23 June 2015

The Director of Planning Services
Arun District Council
Maltravers Road
Littlehampton.

31 Sea Way Ref. No. M/56/15/HH

ROOF PLAN
1.100

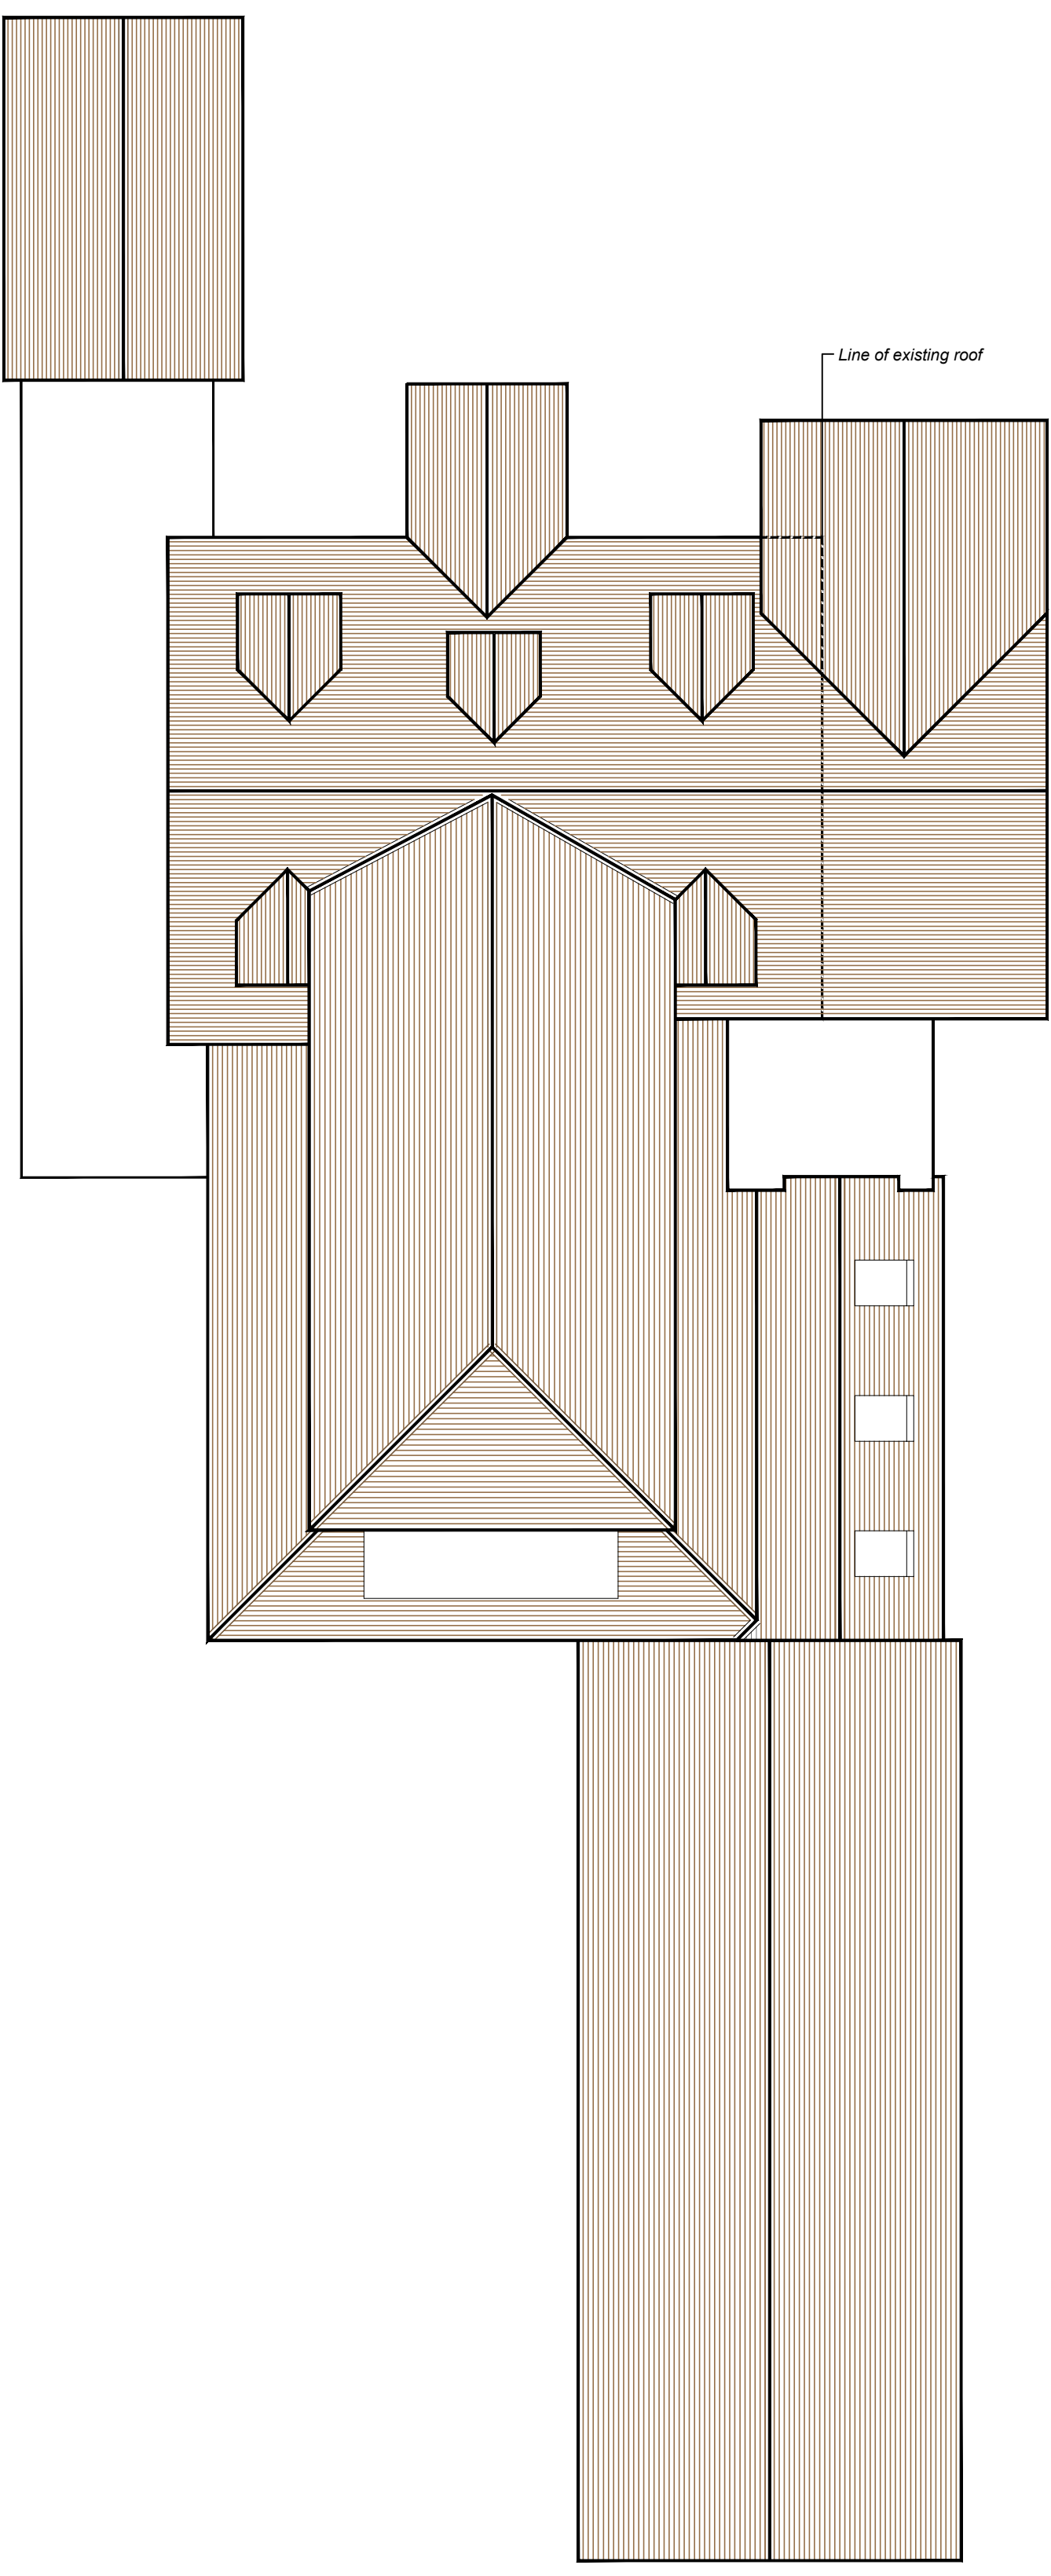
I am writing to urge you to reject this application on the grounds that the additional structures will create a gross over development of this small site, the overbearing nature of the buildings upon the adjoining property, No. 29, and, particularly, the proposed garage and store in the front forecourt.

I do not believe that any case can be made for any further building in the front forecourt. I am aware that there are garages in three of the adjoining houses but in all these cases the garages are in much larger sites well set back from the front verge and far smaller than the large structure proposed so close to both front and side boundaries. Any building in this position will stand out visually from the roadway and will be out of keeping with the adjoining properties.
